Application number: 2023/92966	
What is the application for?:	Demolition of existing dwelling and erection of 97 dwellings including formation
Address of the site or building:	Land to the rear of, 271, Cliffe Lane, Gomersal, Cleckheaton, BD19 4SB
Postcode:

Type of comment: An objection	
Do you wish your comments to be published on the website anonymously?	Yes
2023/62/92966/E	
<p>I wish to object to the inclusion of three storey apartment buildings on this site.</p> <p>I have noticed that in the proposals in the previous application there were to be several split level 2/3 houses but these would not be quite as intrusive as they are set on the incline of the land. This most recent application now includes two three storey apartment blocks, one of which is next to the public footpath between Ferrand Lane and Cliffe Lane. If this new plan is accepted, walkers who enjoy walking down Ferrand Lane and along the footpath to where it meets Cliffe Lane would, as they approached the corner of the site, be met by a large three storey block which, in my view would be very overbearing, and out of place next to the the semi rural nature of the footpath and the fields beyond.</p> <p>It can be ar

FIGURE 02: UKHAB BASELINE HABITAT PLAN

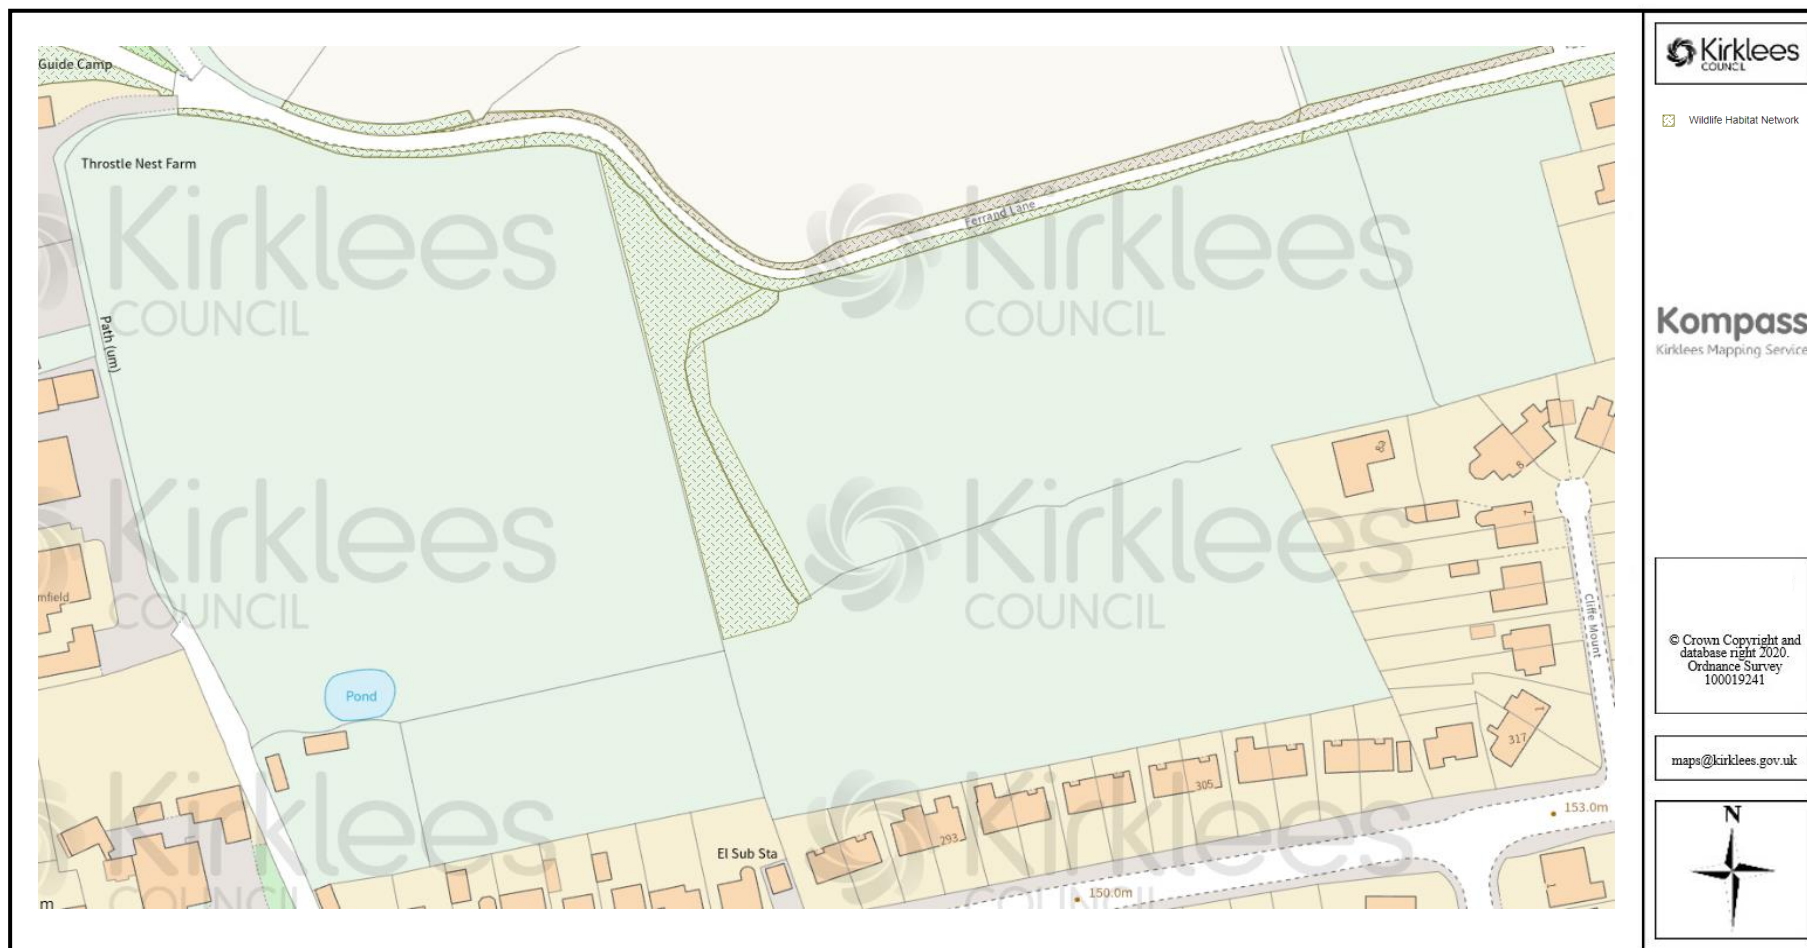
The hedge H1, at the eastern boundary of the proposed development can be seen on the plan on page 26 of the Elliott Consultancy report. It has a B2 classification - "of a condition that they make a substantial contribution to the site" The same identification number is used on the new "proposed landscaping layout" 1062242.

Unfortunately this hedge identification number is not the same in the Smeeden Foreman Ecological Impact Assessment. There is no mention of the importance of hedge H1 because, as close inspection of their plan on page 57 of the report will show, H1 is the identification labelling for the hedge beyond the red line boundary, between the adjacent field and private gardens. The hedge on the red line boundary is labelled H2 and receives a similar positive assessment to the same hedge labelled H1 in that of Elliott Consultancy, (thus allowing continuation of the habitat network). Could I suggest that it would be appropriate if the hedges in the site plan in the Smeeden Foreman report were to be re-numbered so that the red line boundary hedge becomes H1 as in the Elliott Consultancy Report and the Proposed Landscaping Layout, to avoid confusion. This may seem a small detail but when decisions are to be made, I think it is important the information across reports and plans is consistent.

I am concerned that there is varied clarity of detail regarding this hedge H1 and through misinterpretation at some point there could be a danger of the hedge being removed.
